Our ref:DOC19/678467

Your ref: SSD 9667

Subject: EES comments on Environmental Impact Statement for Light Horse Interchange Business Hub Eastern Creek – SSD 9667 – 165 Wallgrove Road and 475 Ferrers Road Eastern Creek

Figure 1: Concept Masterplan by Nettleton Tribe (dated March 2019)

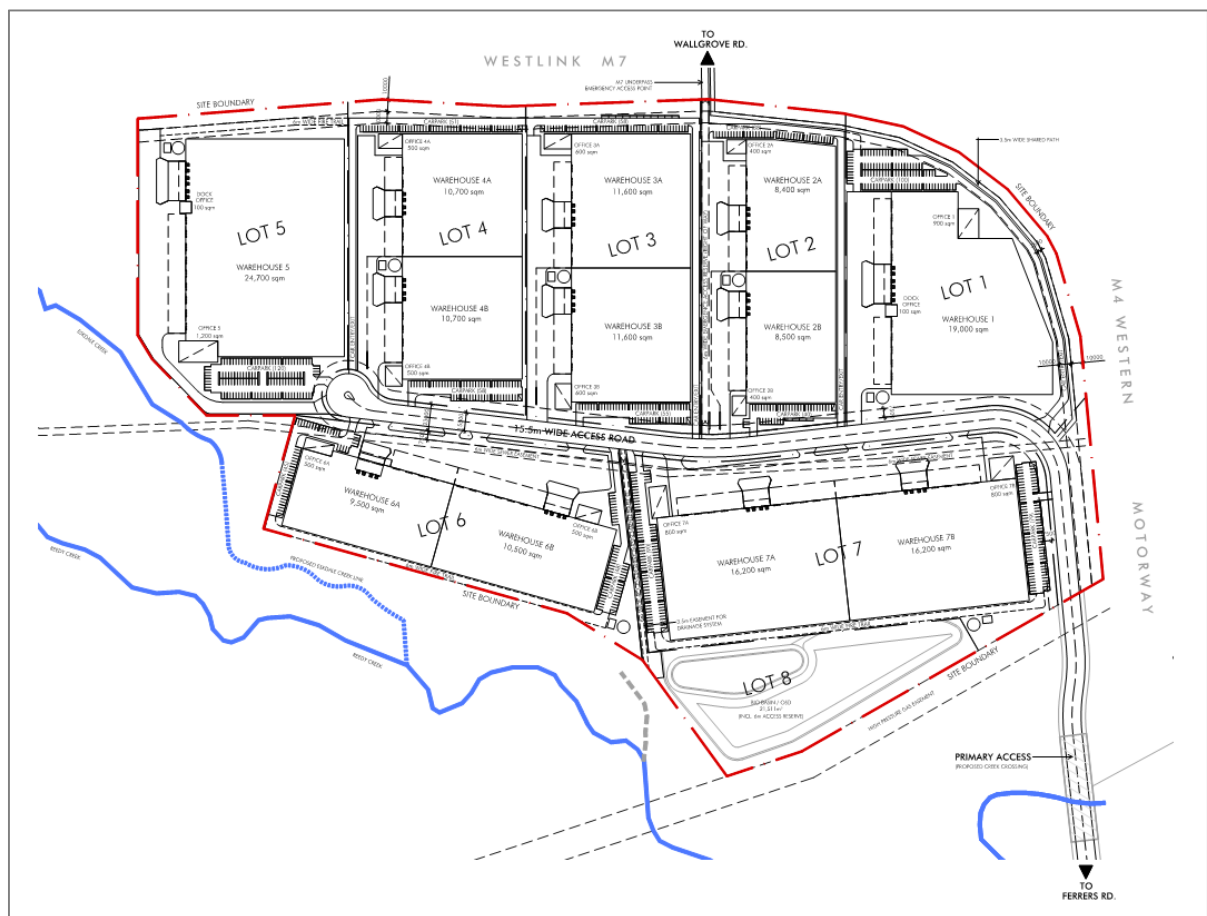
EES recommends the Concept Masterplan is amended to remove Lot 8 (where the bio-retention basin is proposed to be located) from the development footprint and that Lots 6 and 7 are reconfigured. As Lot 8 and potentially part of Lots 6 and 7 appear to retain intact Alluvial Woodland and under-scrubbed Alluvial Woodland which is contiguous with the remnant vegetation to the south of the site (see Figure 3.2 of BDAR), it is recommended that Lot 8 is included as part of the Bushland Corridor and that Lots 6 and 7 are reconfigured and the native vegetation within these lots is included in the Bushland Corridor. The bioretention should be relocated closer to the proposed lots 1-5.
